MEMORANDUM

**CCES RESPONSES**

DATE: May 21, 2019

SUBJECT: SF-19-009– Retreat at Timber Ridge Filing 1  
First Submittal

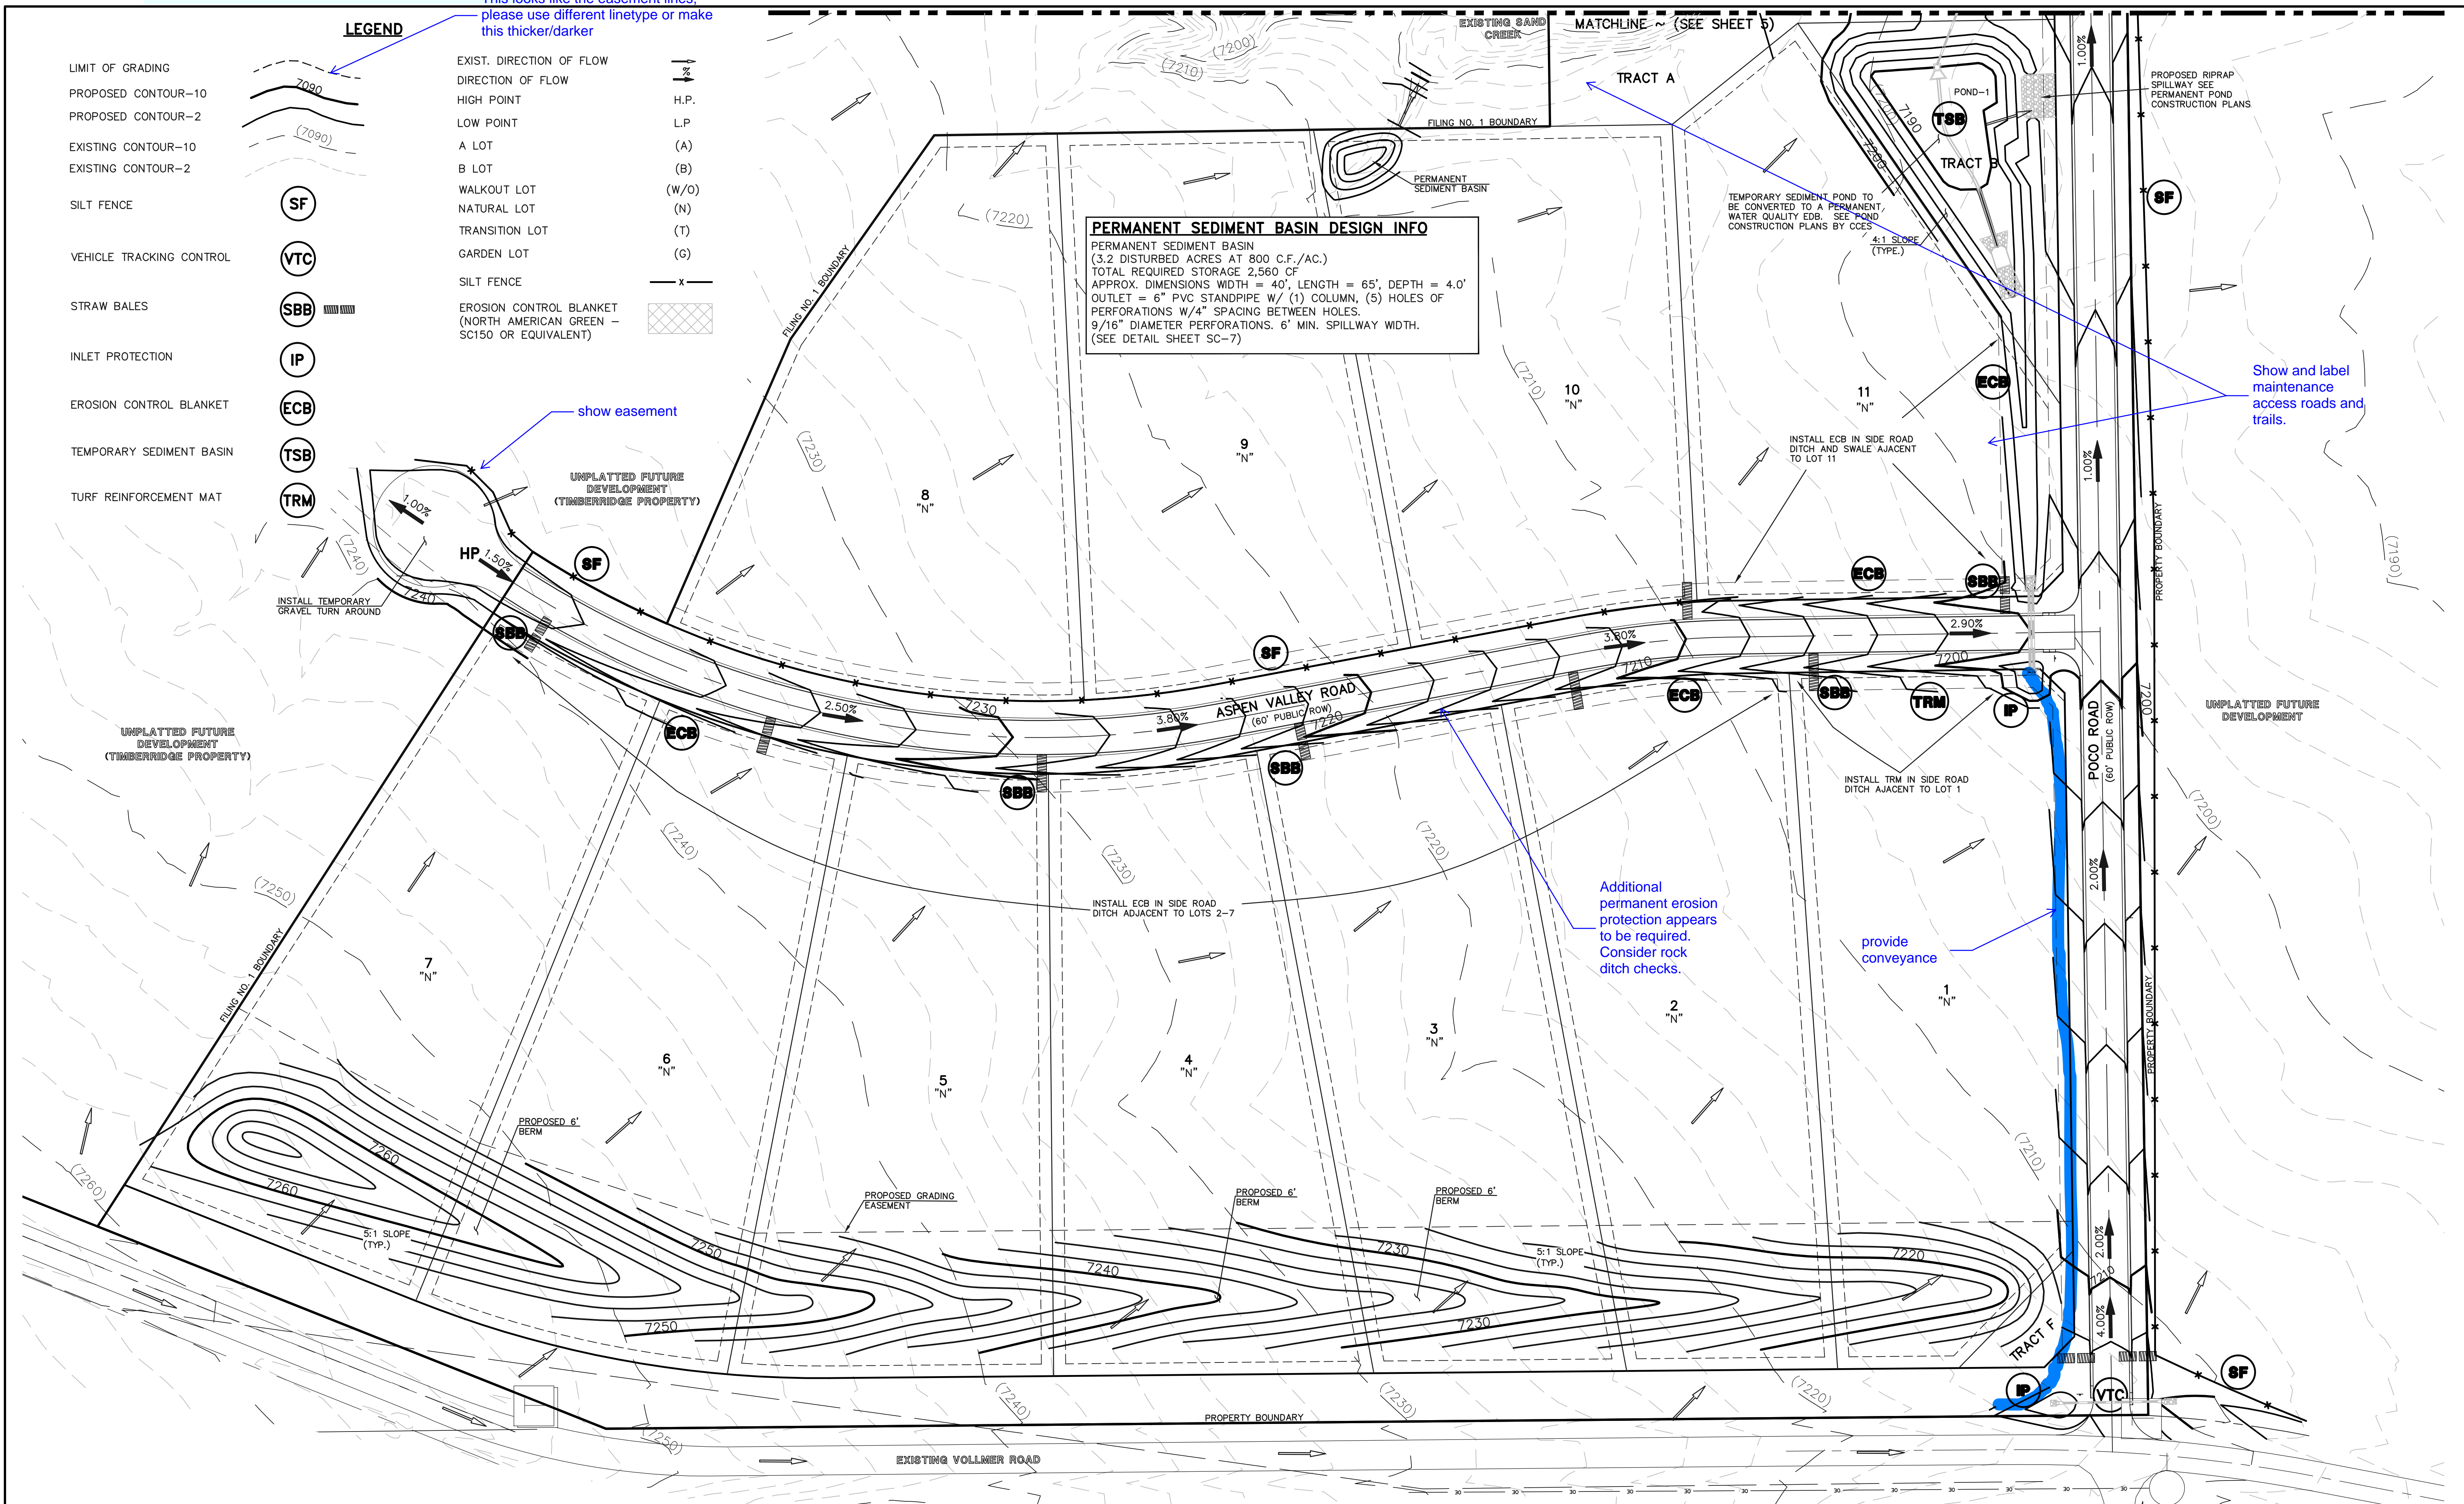
4. Show and label all maintenance access roads and the trail on the plans. **Added**
5. Address TIS revisions in regard to Vollmer Road improvements. **LSC to address in revised report**
